Your Ref: OWPC26083
Our Ref: K/6/20/HH 10-02-2020
Please ask for:
Zac Denton

First floor rear extension, conversion of roofspace to habitable use. Part two storey part single storey front extension and demolition of existing conservatory and adjustments to flat roof dormer to north elevation on existing dormer to incorporate pitched roof.

Flint Barn Peak Lane Kingston

Thank you for your internet representation made on 14th March 2020 which has been recorded as '**an objection**' with the comments as follows:

Client	
Mr K P & Mrs V L Eaton	
Project	
PROPOSED EXTENSION TO FLINT BARN, PEAK LANE, KINGSTON GORSE, WEST SUSSEX, BN16 1RN	
Title	
PROPOSED SECTION	
Drawing Status	
PLANNING APPROVAL	
Drawn	Checked
KPE	
Scale	
1:50 @ A3	
Date	
31 Jan 2020	
Job No	
20/01	
Drawing Number	
2020/Jan/Plan. 004

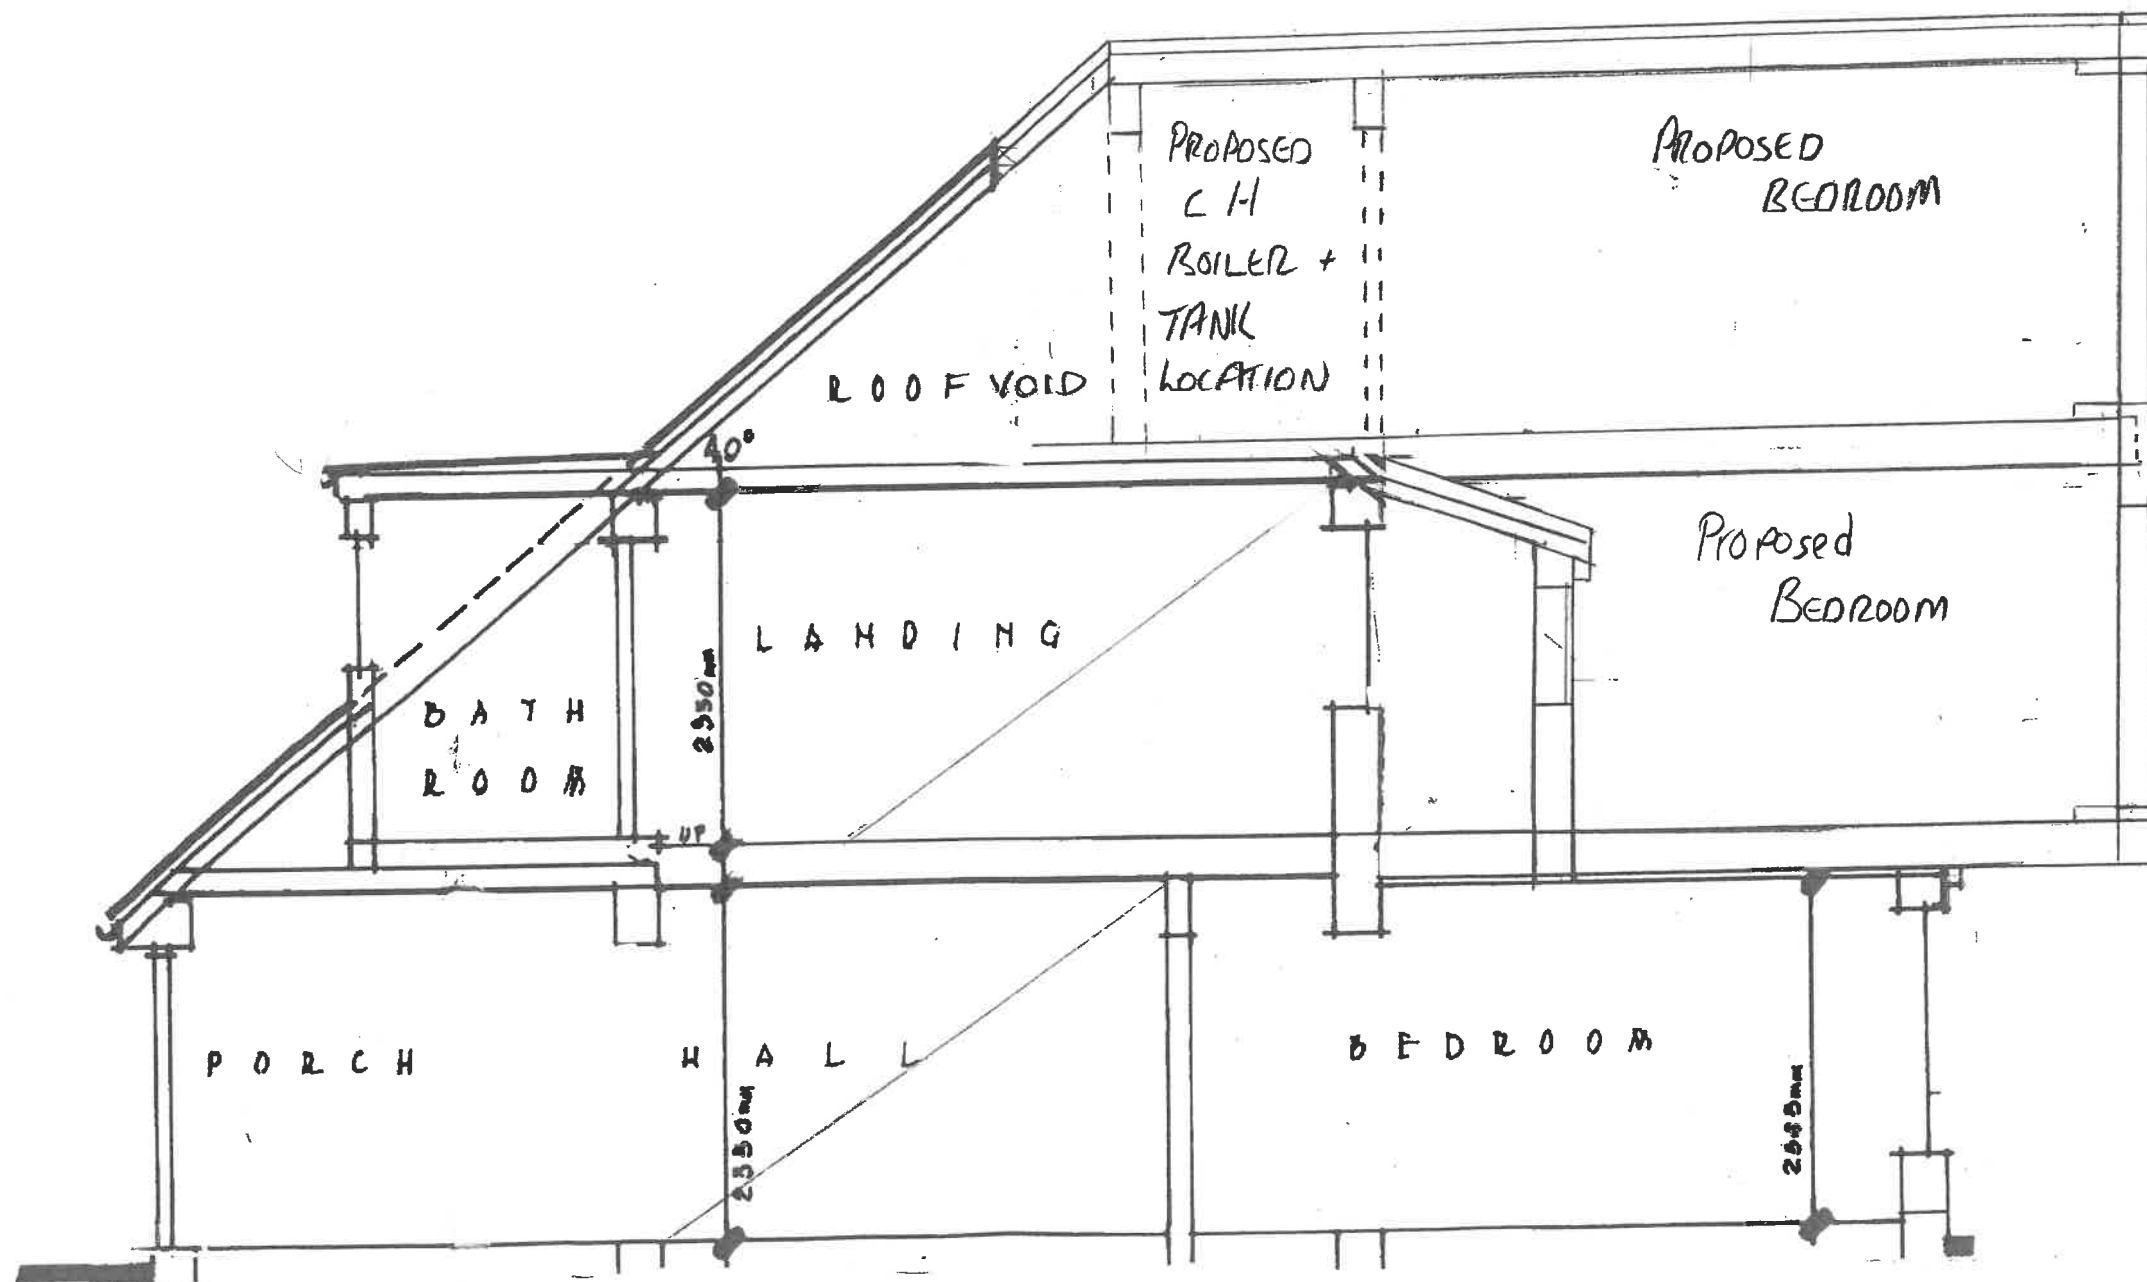
We are most concerned about the lack of clarity regarding the finished roof height of the proposed additional storey in comparison with neighbouring properties. Also the lack of information regarding materials to be used to clad the exterior.
